Recommendation Report for Planning Permission for Works or Extension to a Dwelling

REF NO: FP/276/18/HH

LOCATION: 31 South Drive
Felpham
PO22 7PY

PROPOSAL: Single storey rear extension & conversion of roofspace to habitable use to include a front & rear dormer.

Proposed Ground Floor Plan

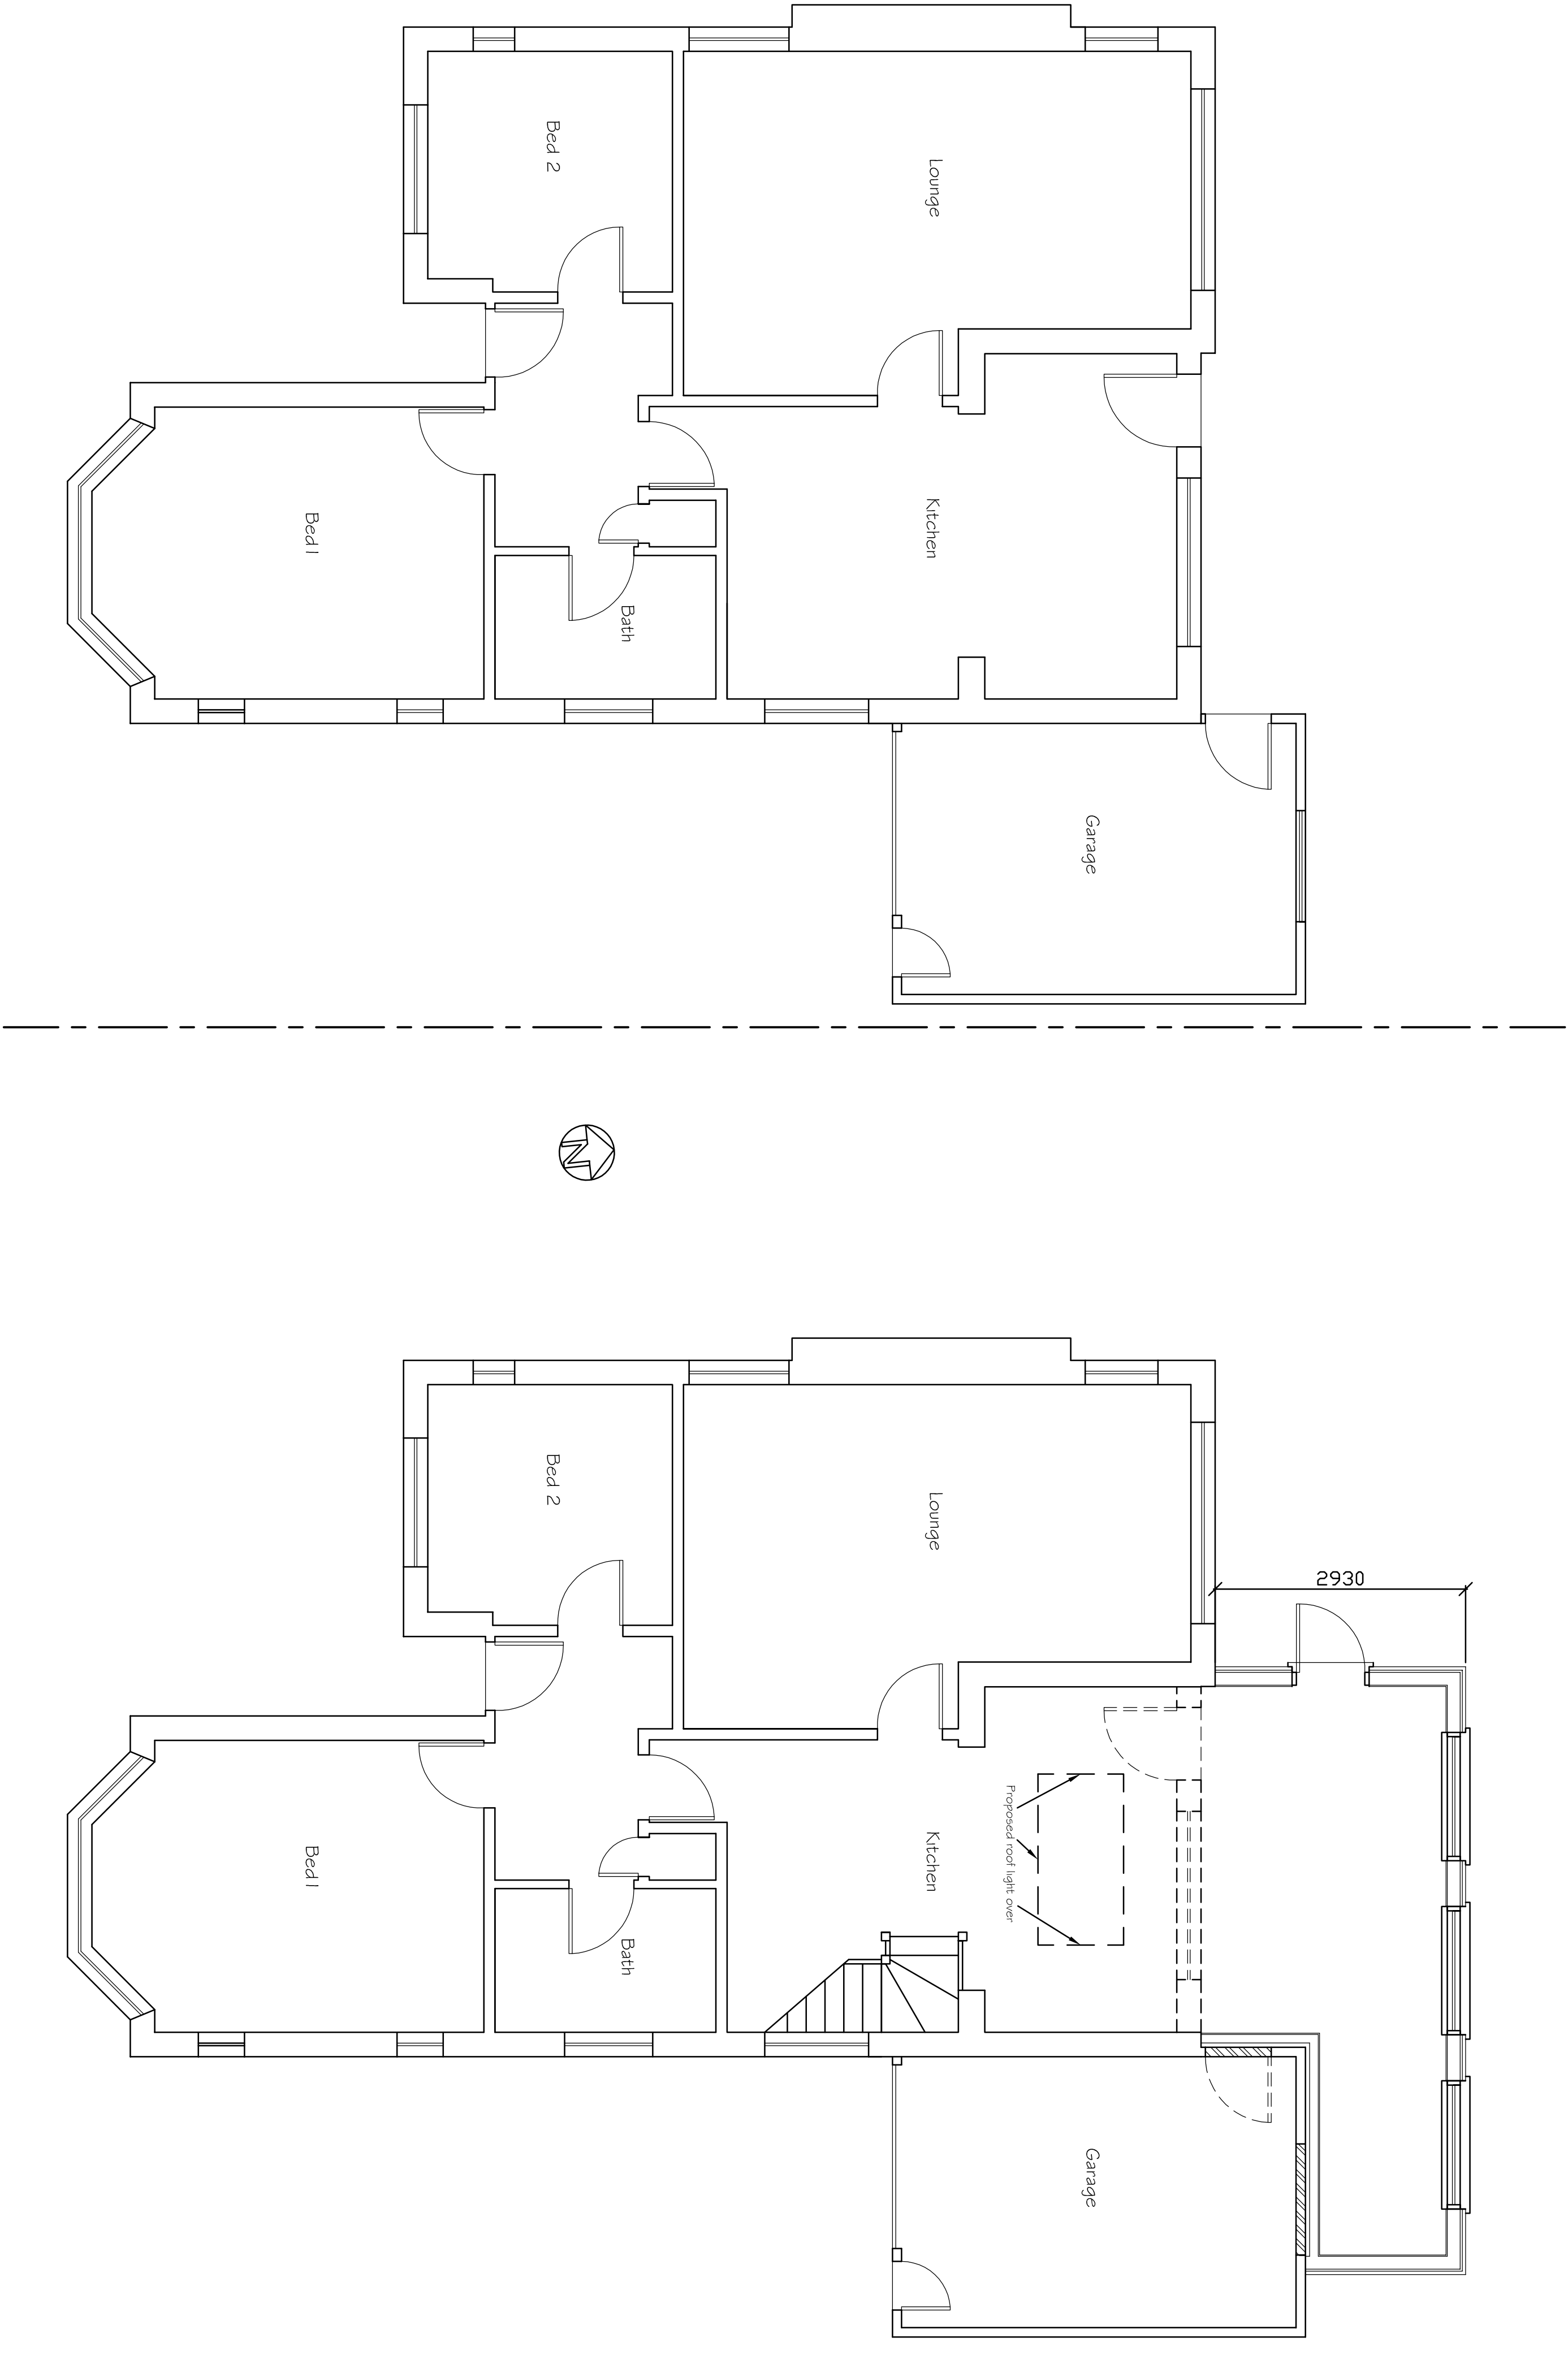
The proposed rear extension will extend to a depth of approximately 2.9m. This will extend around 1.85m beyond that of the existing garage. This would retain around 1m the eastern boundary and 5.85m to the west. The rear extension will meet in line with the rear wall of both neighbouring properties and as such is not considered to result in any adverse overshadowing. The roof will be flat to a height of around 2.8m to a maximum of around 3.2m with the installation of a roof lantern.

Proposed Front (South) Elevation

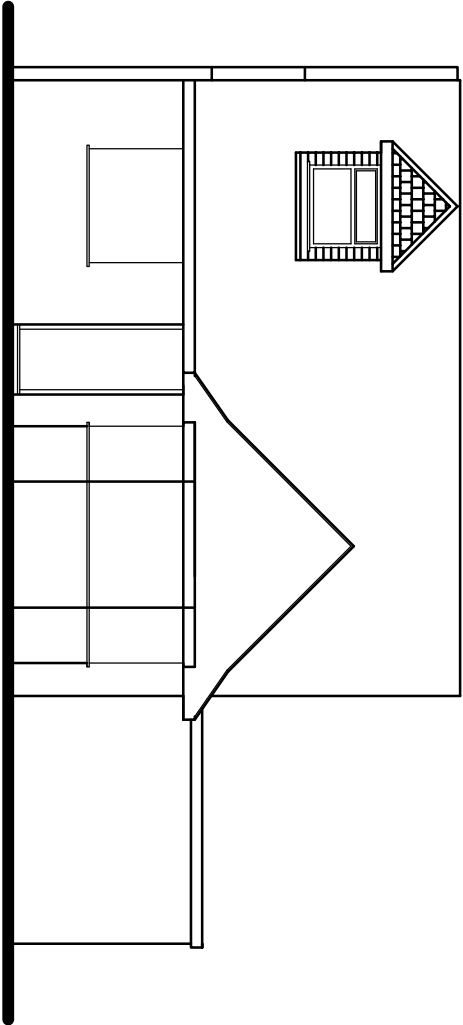
The development proposes a dormer to the front elevation of the property and is therefore visible from the street scene.

The surrounding area consist of housing of a mixed character and design with No.42 also having dormers to the front similar to what is proposed and it is therefore considered the development is not out of keeping with area. The proposed development appears subservient and well integrated with the host dwelling. The proposed dormer is modest in size and does not appear overly dominant to the front elevation of the dwelling.

The development seeks a dormer to the front and rear elevation of the dwelling. The front dormer is modest is size and will have views over the street scene. Due to its siting it is not considered to appear overbearing or overshadowing upon neighbouring properties.

Proposed Side (East) Elevation

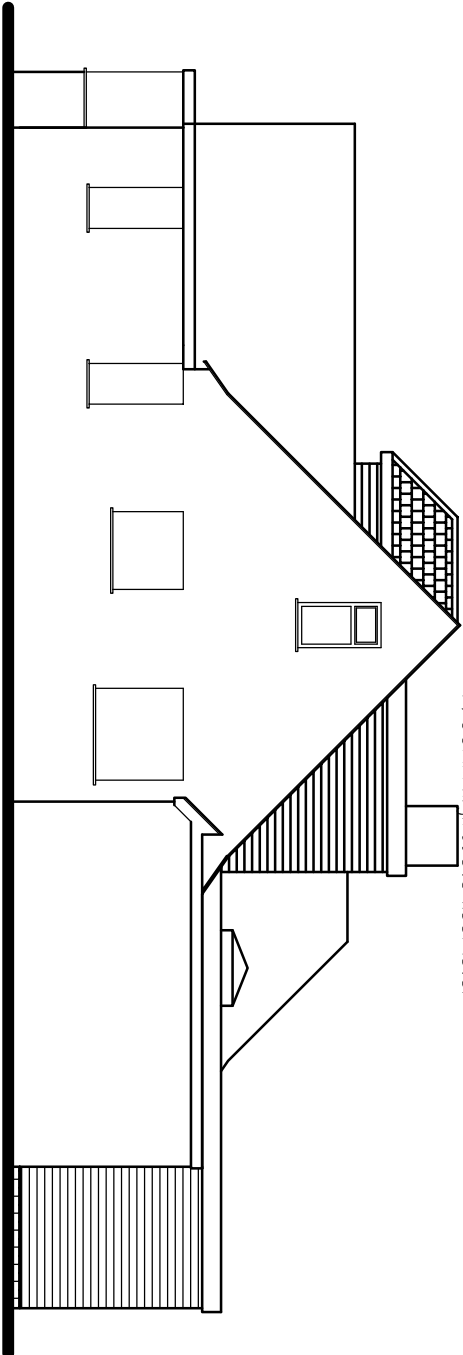
A window is also proposed to the eastern side elevation of the dwelling. This is to be obscured glazed as shown on the plan to ensure there is no adverse impacts as a result.

- 3 The first floor window on the eastern elevation of the building shall all times be glazed with

obscured glass and only openable at a high level, at least 1.7m above finished floor level.

Proposed Rear (North) Elevation

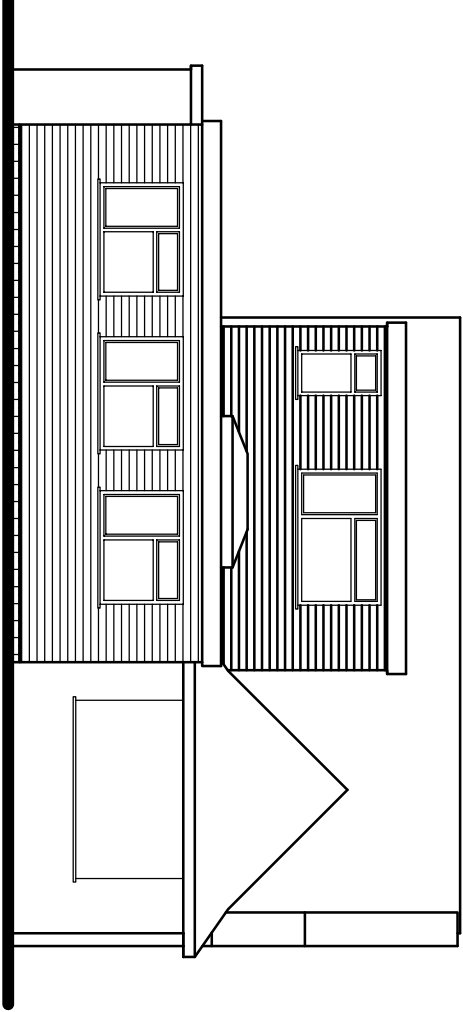
The dormer to the rear will be larger and set around 0.7m below that of the ridge height of the dwelling. It will have a width of 4.55m and a depth and height of 2.6m. Due to the siting it is not considered to appear overbearing or overshadowing upon the neighbouring property to the east with sufficient separation retained. There will be 2 windows to the rear dormer with them serving a landing and bedroom however again due to the siting and with 18m retained to the rear boundary, it is not deemed to give rise to adverse overlooking upon neighbouring amenity.
